Cc: Jamey Ayling <jamey.ayling@co.kittitas.wa.us>; Chace Pedersen <chace.pedersen@co.kittitas.wa.us>; Zach Torrance-Smith <zach.torrancesmith@co.kittitas.wa.us>; Bradley Gasawski <bradley.gasawski@co.kittitas.wa.us>
Subject: [Ext] SP-23-00011 Barker - NOA Memo

TO: All Staff
FROM: Public Works Plan Review Team
DATE: December 22, 2023
SUBJECT: SP-23-00011 Barker

RE: SP-23-00011 Barker

BARKER SHORT PLAT  
PART OF SECTION 6, T. 17 N., R. 20 E., W.M.  
KITITAS COUNTY, WASHINGTON

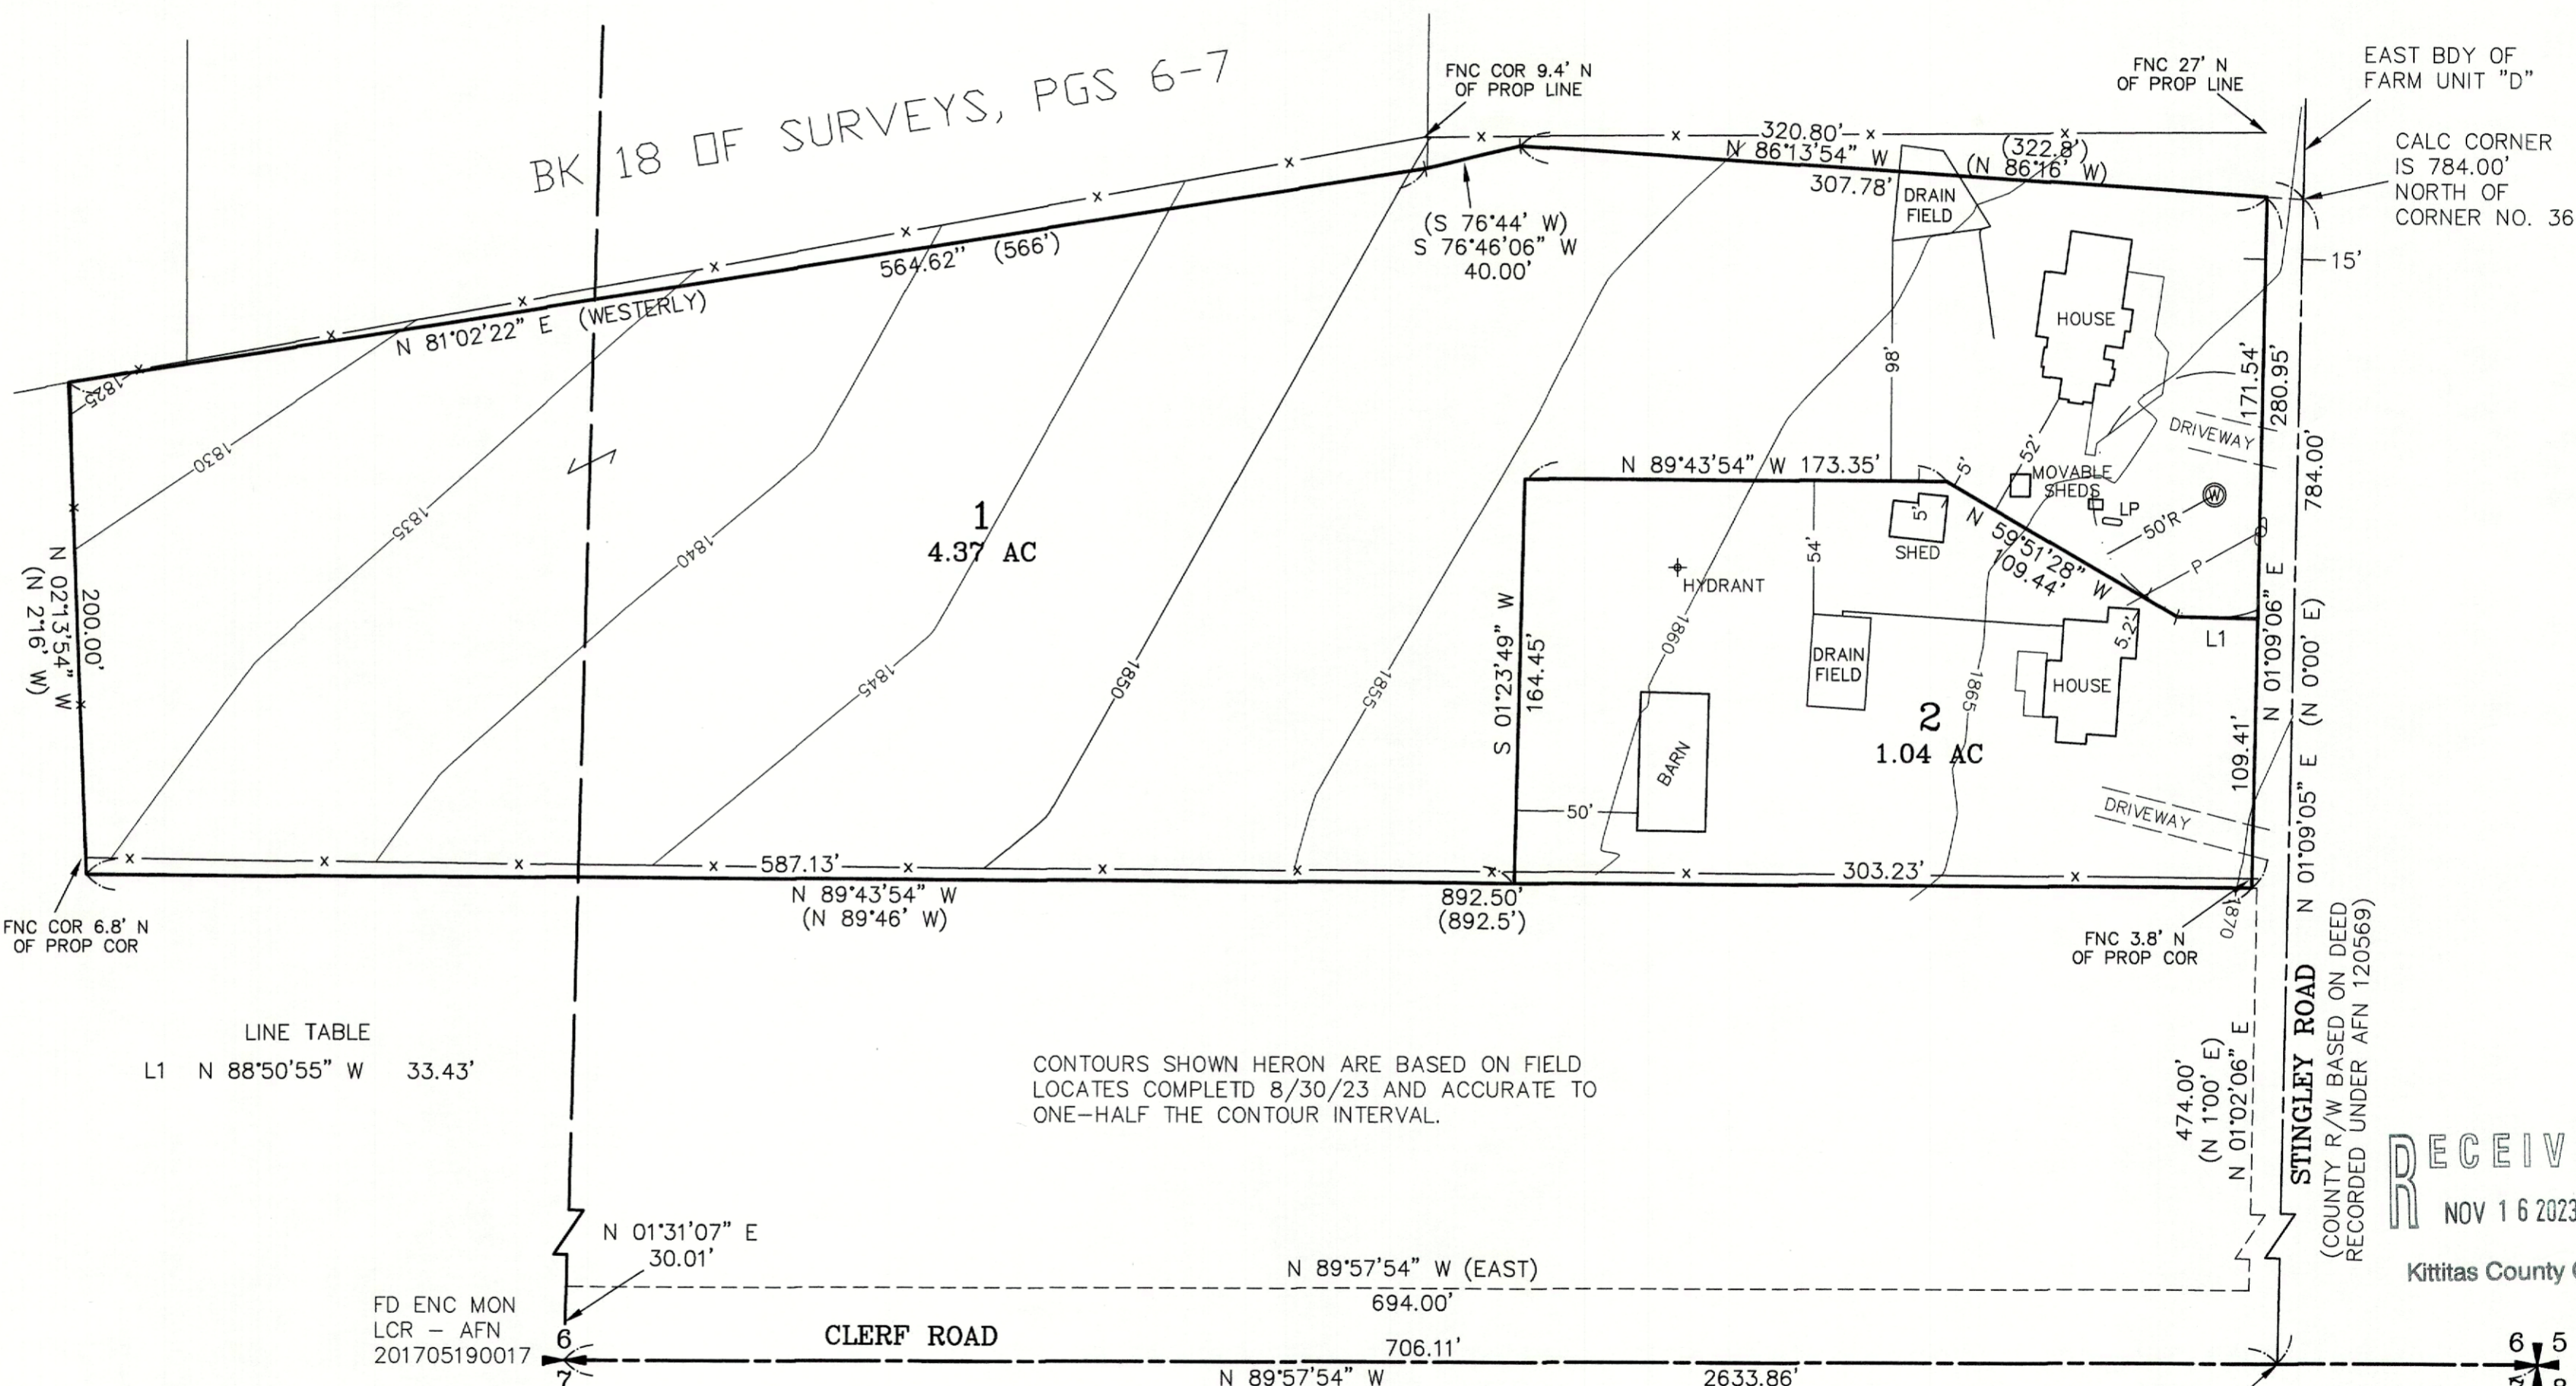
ACCESS	<ol style="list-style-type: none"> 1. Existing addresses are required to be assigned to the new parcels created in this short plat. 2. An approved access permit shall be required from the Department of Public Works prior to creating any new driveway access or performing work within the county road right-of-way. 3. Any further subdivisions or lots to be served by proposed access may result in further access requirements. See Kittitas County Road Standards. 4. Maintenance of the access is the responsibility of the property owners who benefit from its use. 5. In addition to the above-mentioned conditions, all applicable Kittitas County Road Standards apply to this proposal.
ENGINEERING	<ol style="list-style-type: none"> 1. Except as exempted in Section KCC 14.05.060, no grading or filling upon a site involving more than one hundred (100) cubic yards shall be performed without a grading permit from the County Engineer or Public Works designee (KCC 14.05.050). An application for grading in excess of five hundred (500) cubic yards shall be accompanied by an engineered grading plan (KCC 14.05.080).

SURVEY	Application does not meet the requirements of WAC:332-130-145. (JT)
TRANSPORTATION CONCURRENCY	No Transportation Concurrency Comments. (TM)
FLOOD	Parcel # 890533 is not located in the FEMA identified special flood hazard area (100-year floodplain). (SC)
WATER MITIGATION/ METERING	Water mitigation and metering standards in KCC 13.35.027 for plat approval are satisfied since the houses share an existing exempt well and the proposed project does not include a new use of groundwater. (SC)

The proposed short plat drawing indicates there is an existing well on proposed lot 1. The applicant also indicates the existing well is a shared well.

A well log for the existing well on lot 1 must be submitted as well as a signed, notarized and filed shared water user's agreement must be submitted for review.
